Consultation Response from KC, Lead Local Flood Authority
2024/92576 site of, Former Spotted Cow Pub, New Hey Road, Oakes, Huddersfield, HD3 4BU
Discharge of details reserved by conditions 3 (CMP), 21 (retaining walls), 23 (surface water) and 28 (non-native species) of previous permission 2021/94029 for demolition of existing structures and erection of foodstore (class E) with associated access, parking, servicing areas and landscaping
Date Responded: 5th January 2025 Responding Officer: Paul Farndale

Condition 23 Drainage

| Title | | DRAINAGE ARRANGEMENT SHEET 1 OF 2 | |

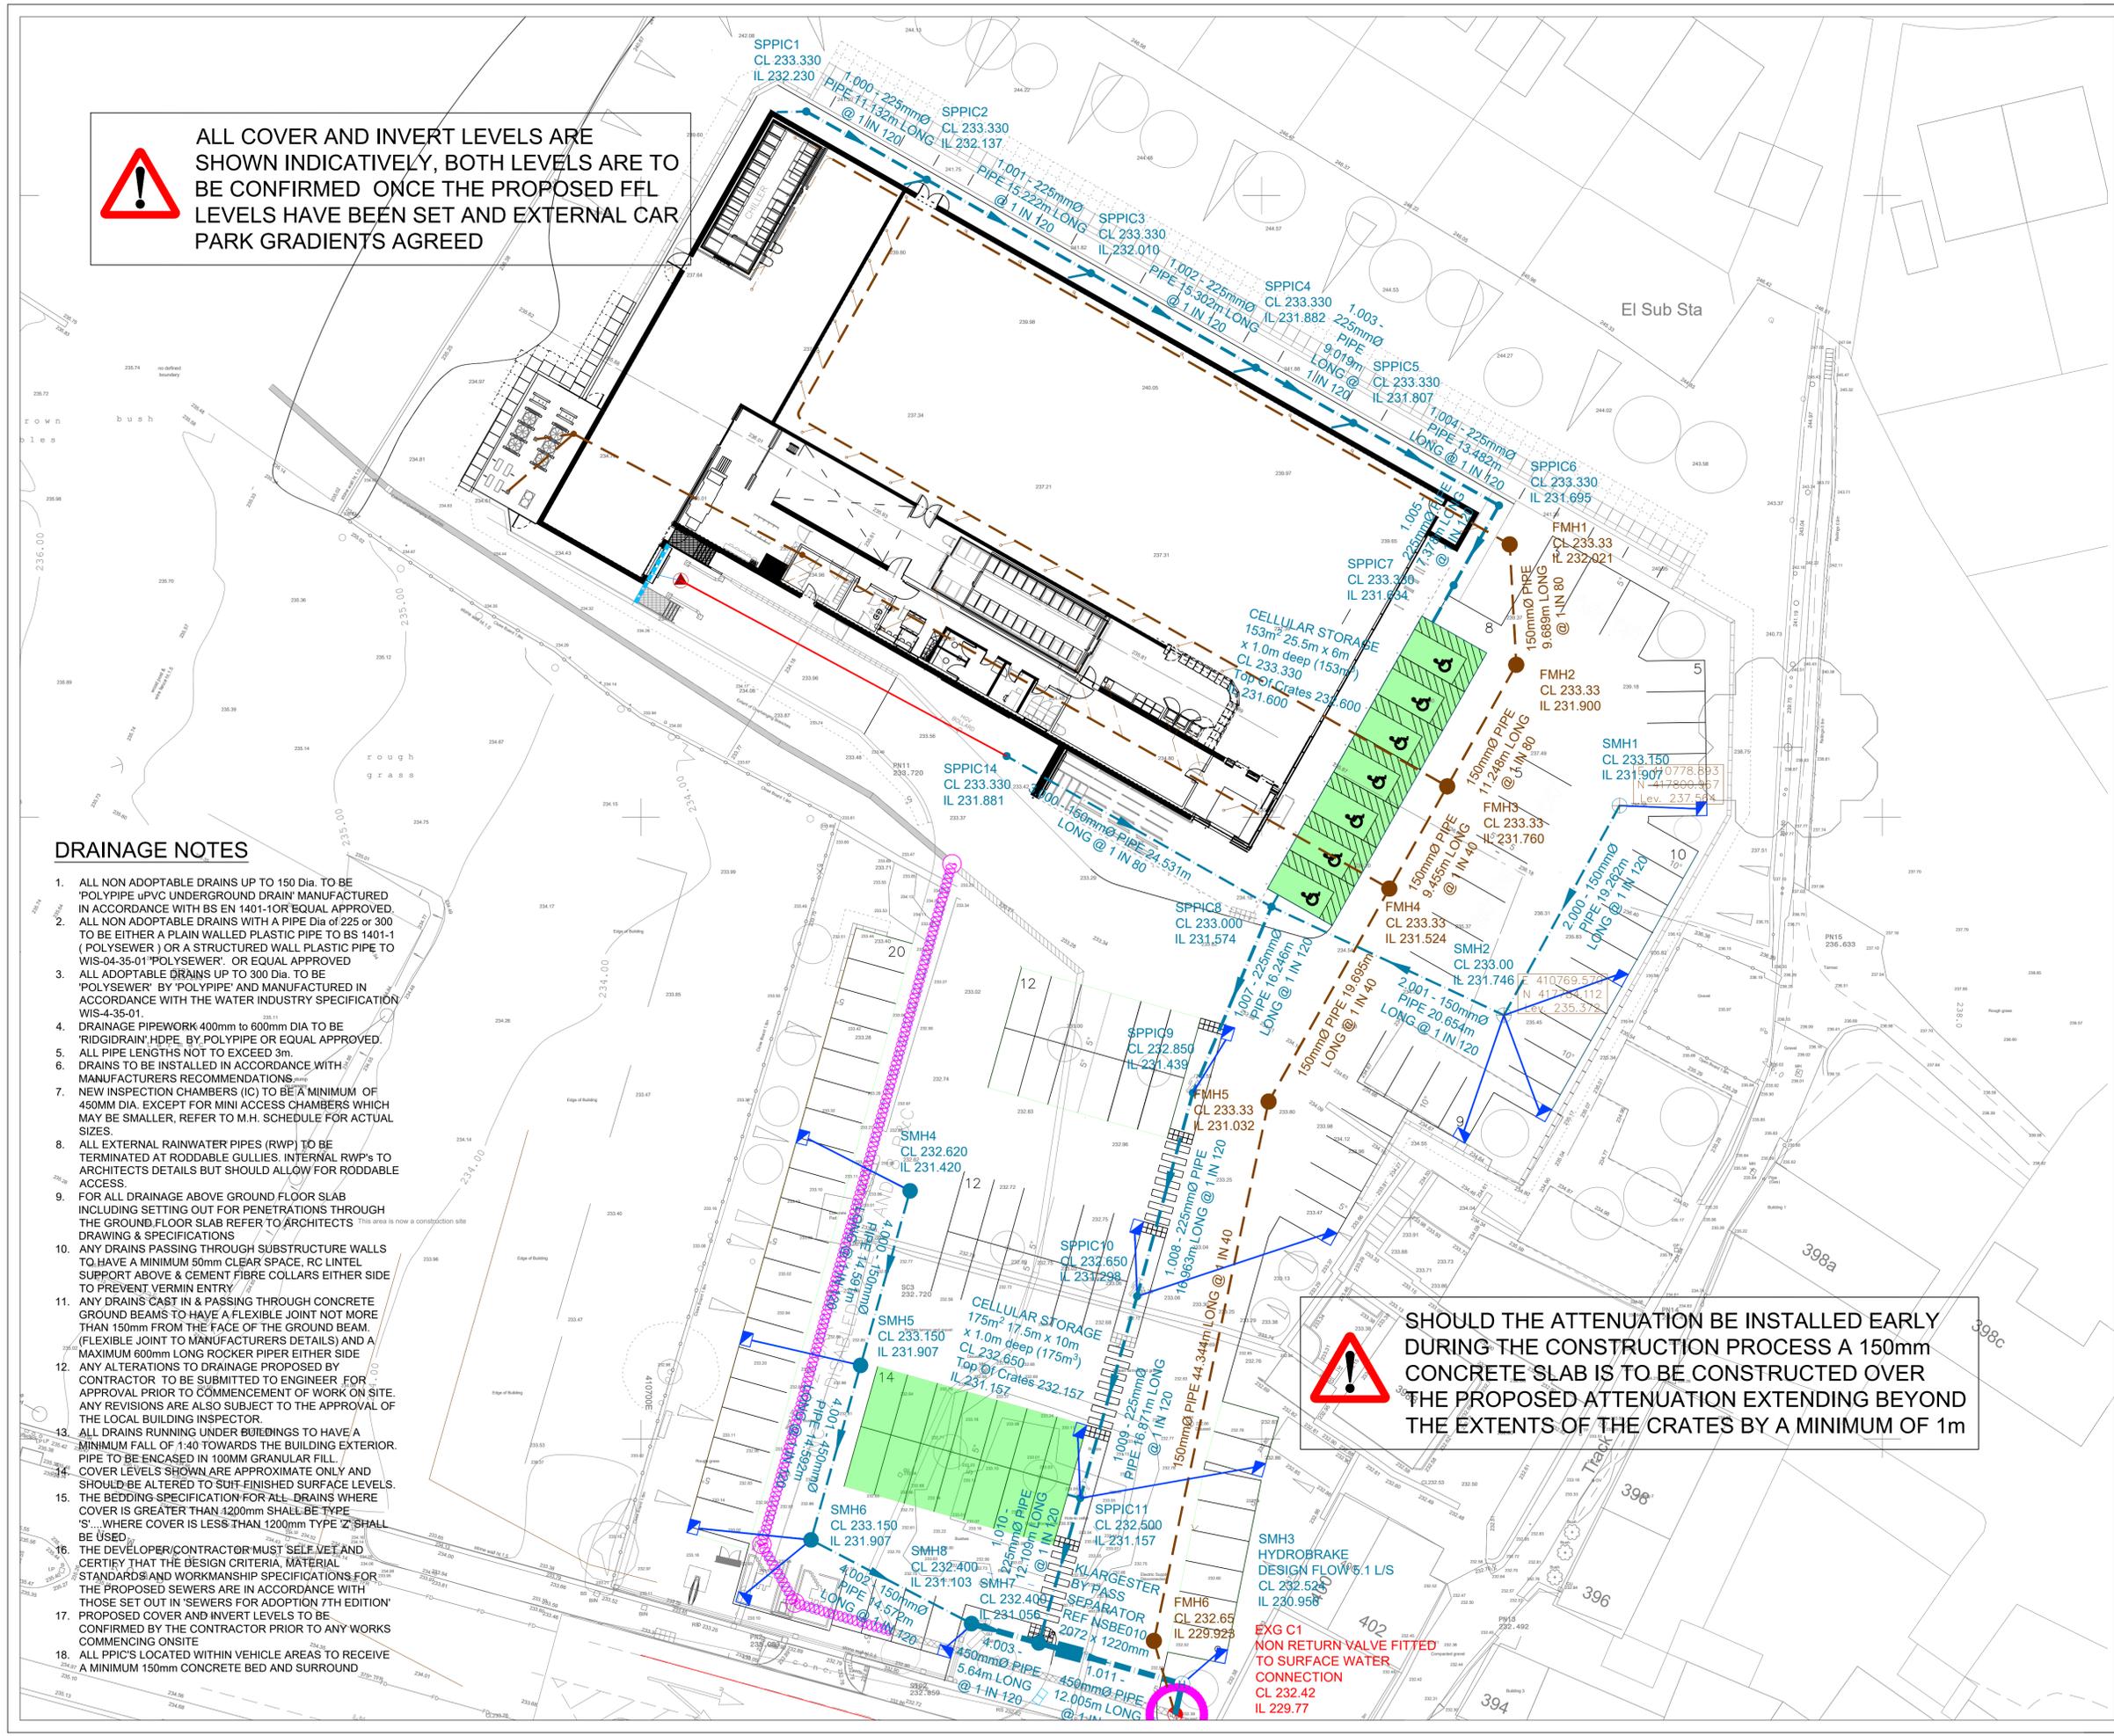
An assessment of the max weight of vehicles to be visiting the site (HGV's, e.g. delivery trucks) in relation to minimum depths required from polystorm R is still required. One of the tanks has less than 500mm in cover and would appear to be non-compliant.

One of the tanks has only one catchpit to work from. Central or intermediate access (shown on typical drainage details) appear to be omitted from the final design. This compromises the language of the maintenance plan.

The hydraulic design requires altering and simulation rerunning. All invert levels should be checked and cross referenced and associated pipe sizes and cover levels. It appears that both tanks I.L is different on the new drainage plans submitted compared to the hydraulic design, one by over 400mm. Full calculations should be checked and resubmitted.
